From: Maria Tomalova <Maria.Tomalova@arun.gov.uk>
Sent: Wednesday, September 13, 2023 5:54 PM
To: Planning.Responses <Planning.Responses@arun.gov.uk>
Subject: FW: Y/105/19/PL and Y/106/19/L, Stakers Farm

From: Maria Tomalova
Sent: Thursday, June 18, 2020 12:59 PM
To: Ben Daines [REDACTED]
Subject: Y/105/19/PL and Y/106/19/L, Stakers Farm

Please see below Martyn's comments in red and mine in green.
(your email from 22nd May 2020)

Drawing Title
Existing and Proposed Elevations - Barn 1

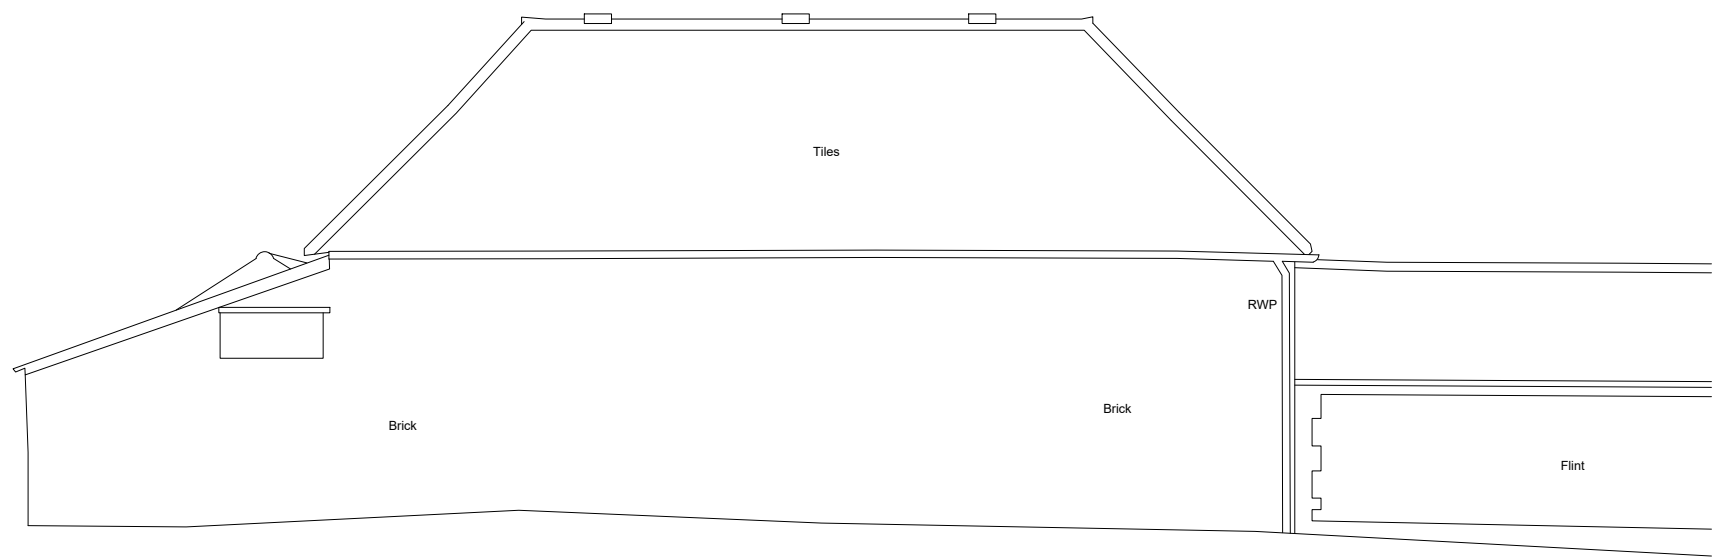
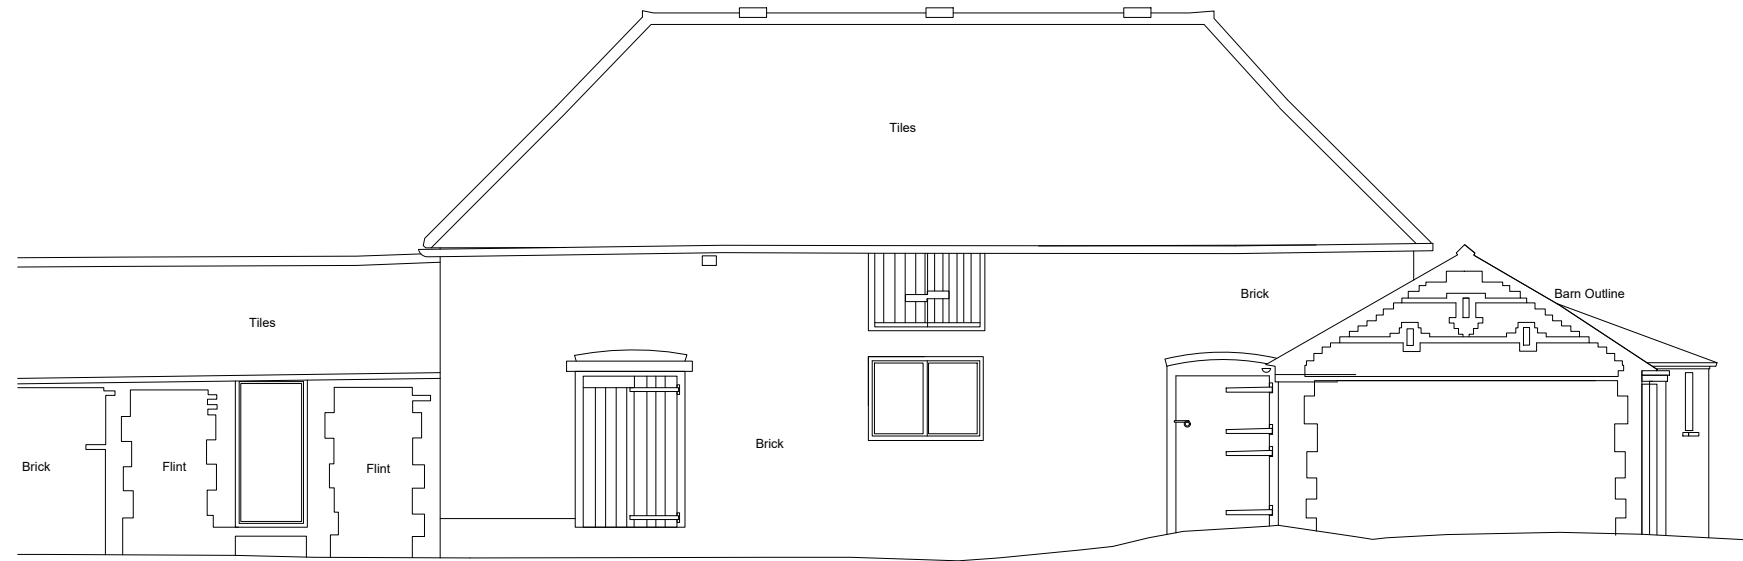
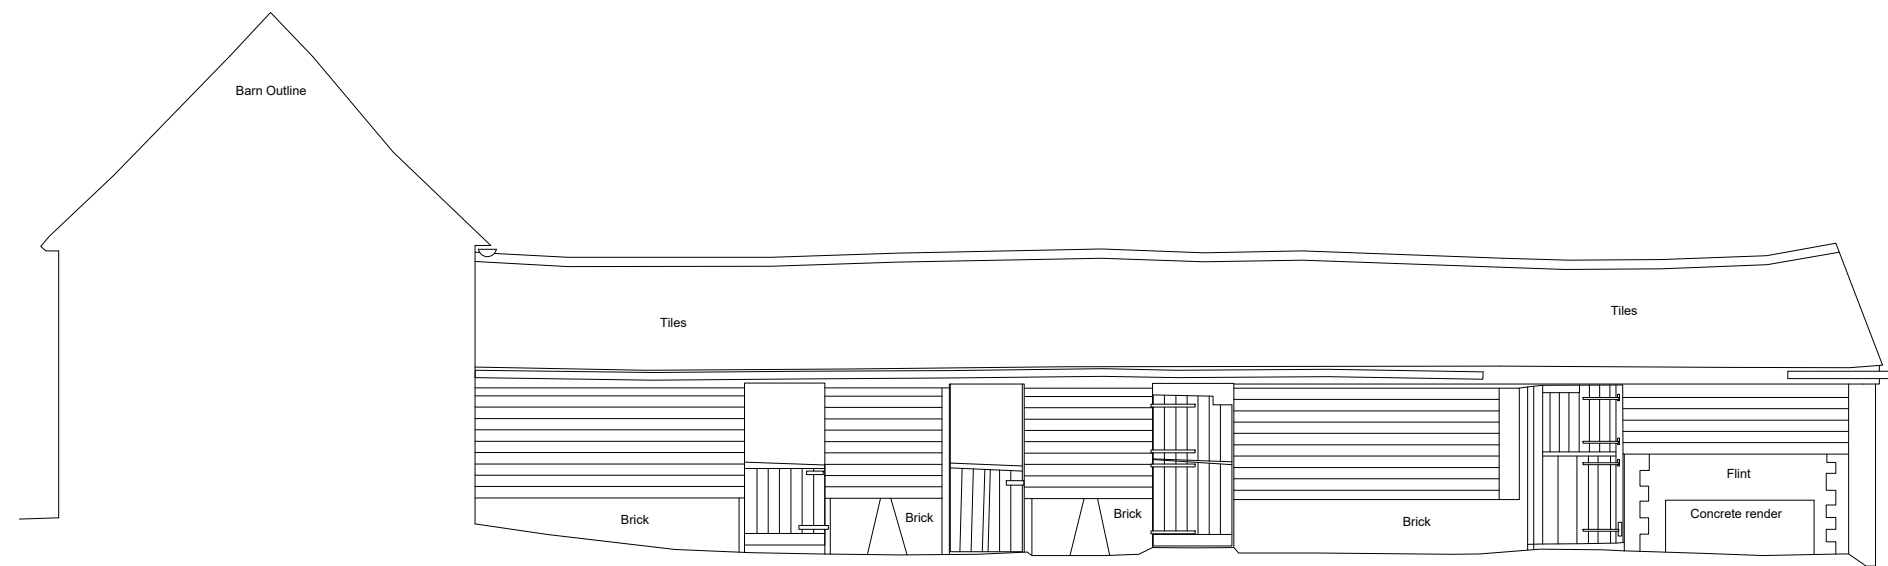
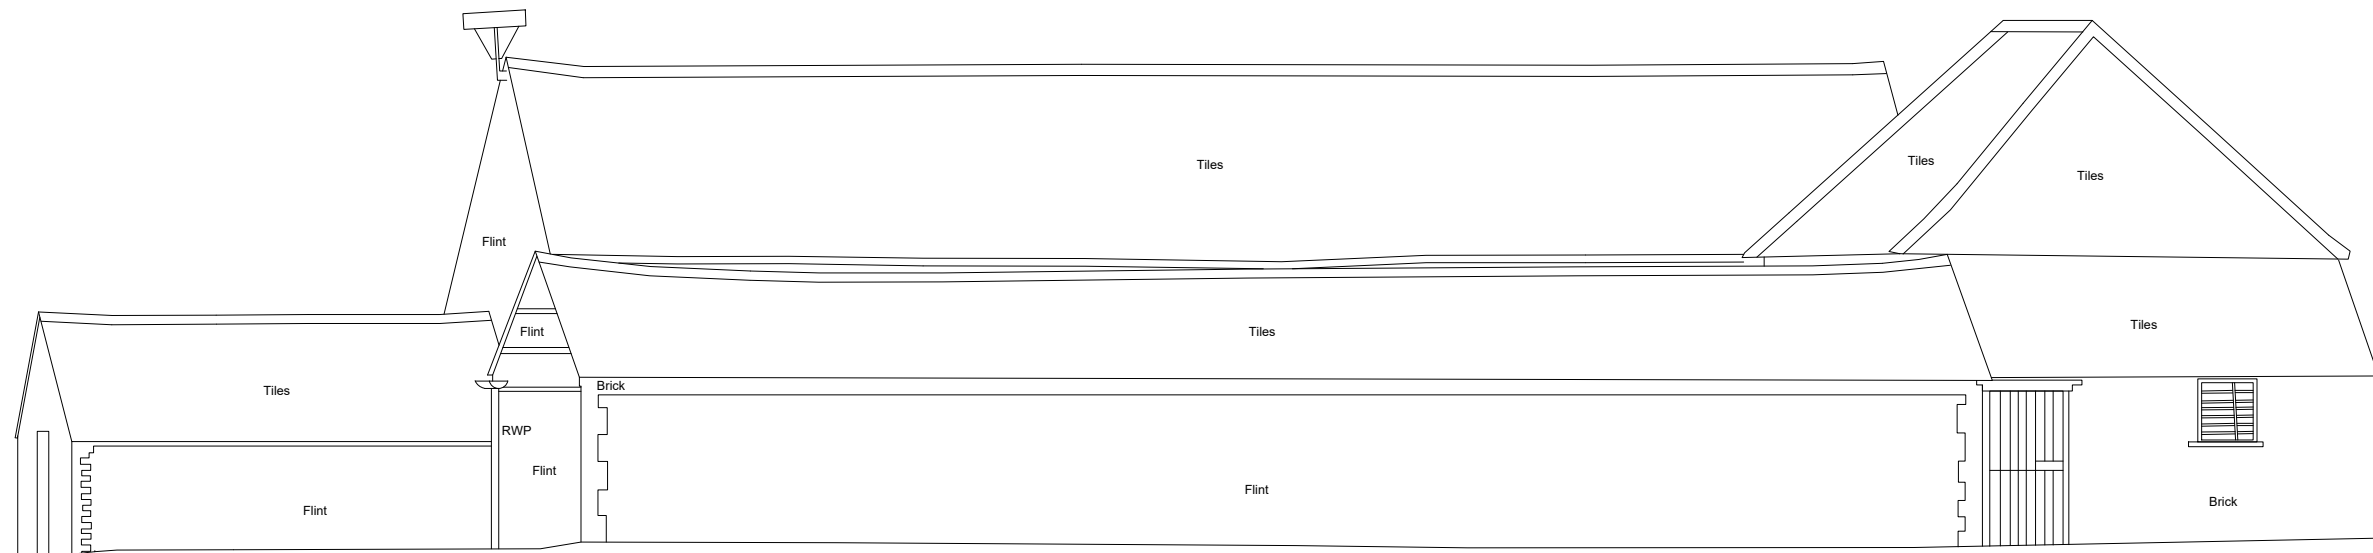
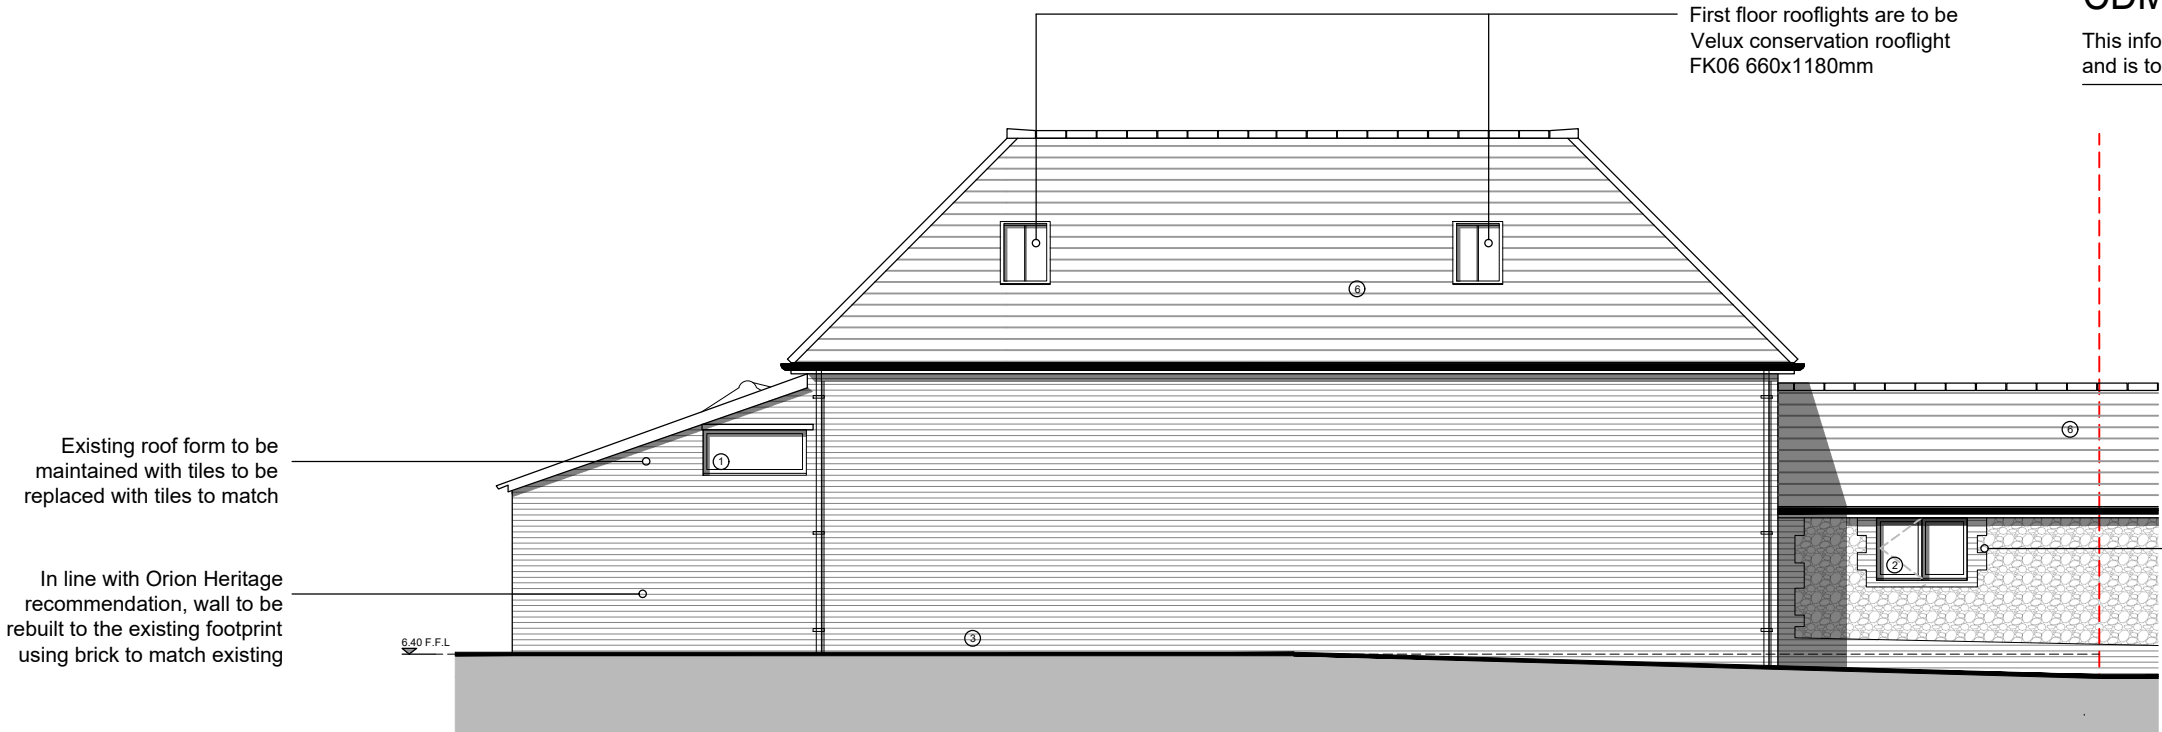
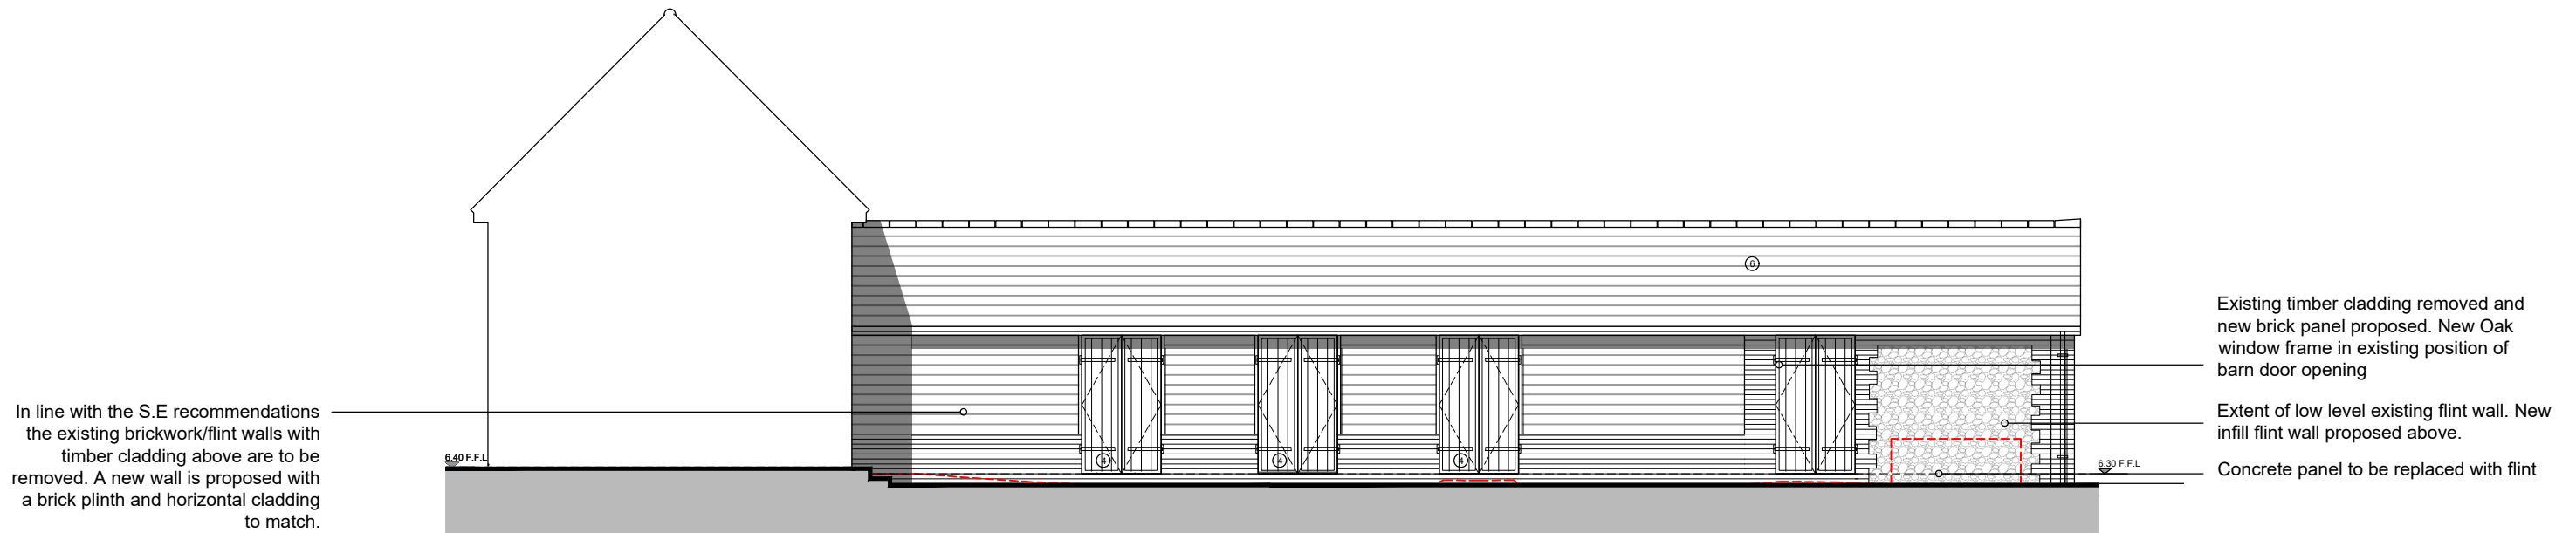
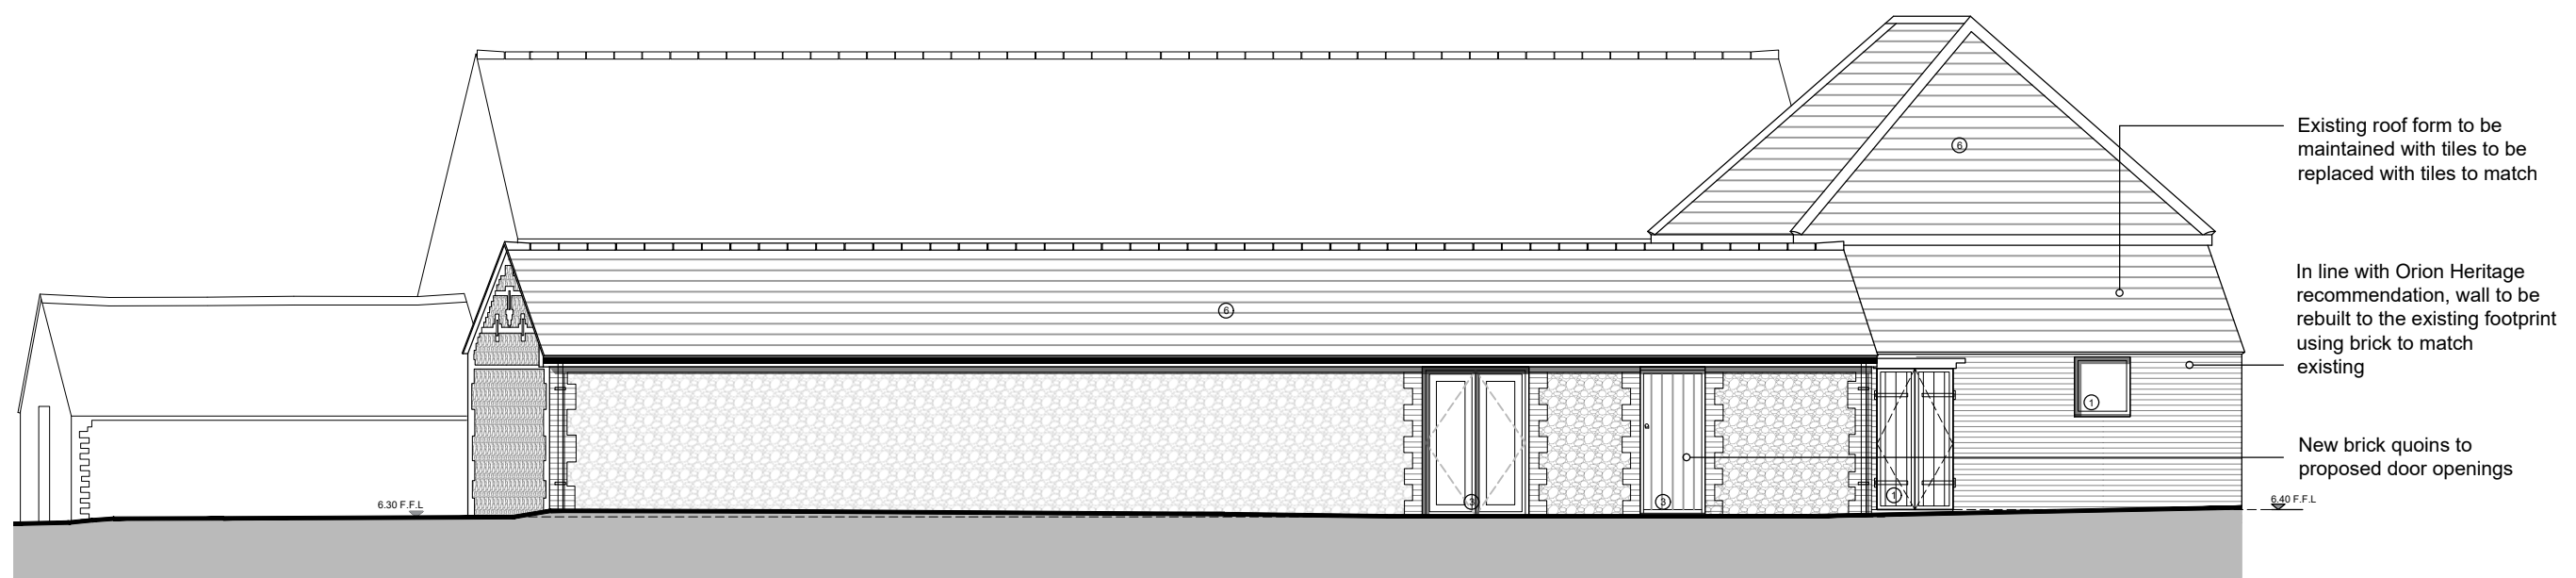
South elevation – we will amend the proposed alterations to the single storey element and reduce the amount of glazing, ensuring that this elevation is changed as little as possible from the existing situation.

There should be as few rooflights as possible, and these should be placed on the rear elevations where they will not be visible. They should also be of conservation standard. No roof-lights on primary elevation. A casual glance should not reveal that the building has been converted. This means that unconventional arrangements of rooms are required. Roof structures comprise a dominant visual feature and should be left uninterrupted.
